“AMENDMENT” OF THE PRELIMINARY DRAINAGE REPORT

Claremont Business Park 2 Filing No.1

A RESUBDIVISION OF TRACT C OF CLAREMONT BUSINESS PARK FILING NO. 2

JULY 2020

PROPOSED DRAINAGE MAP

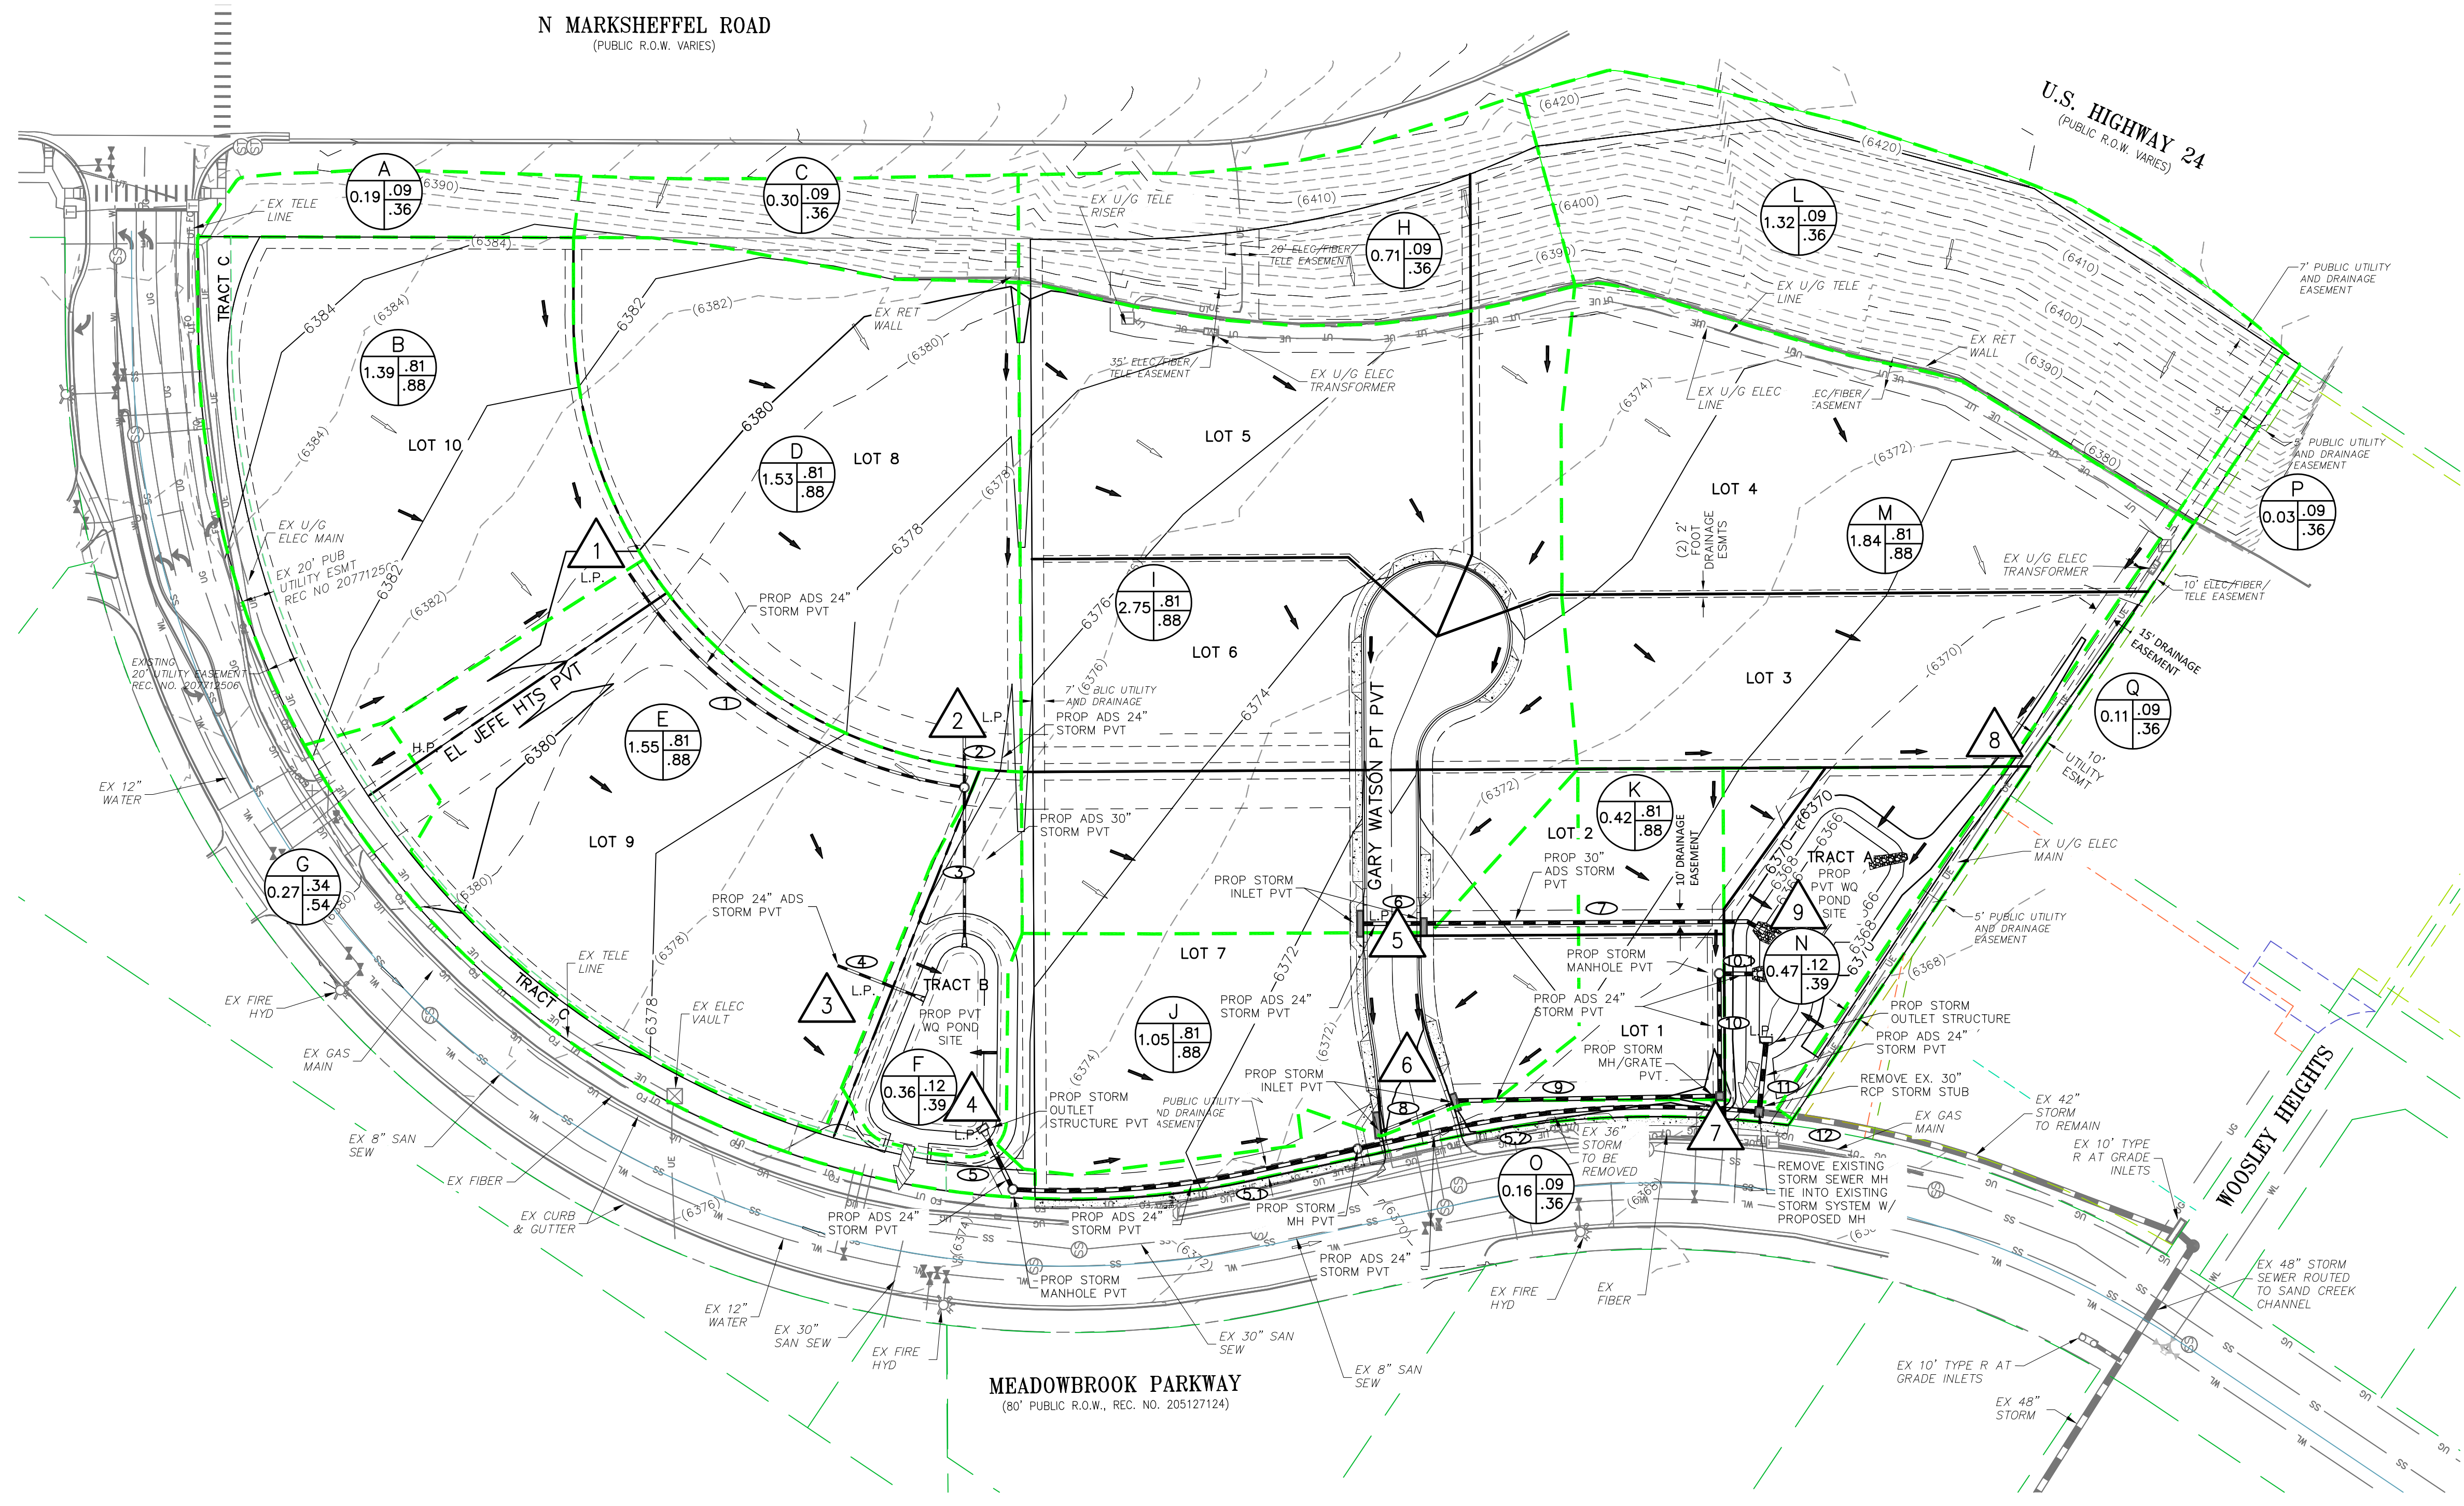
The callout for the 36" pipe is located in basin O. revise accordingly.

It appears that the existing 30" stub may conflict with your proposed 30" ADS pipe. Please clarify.
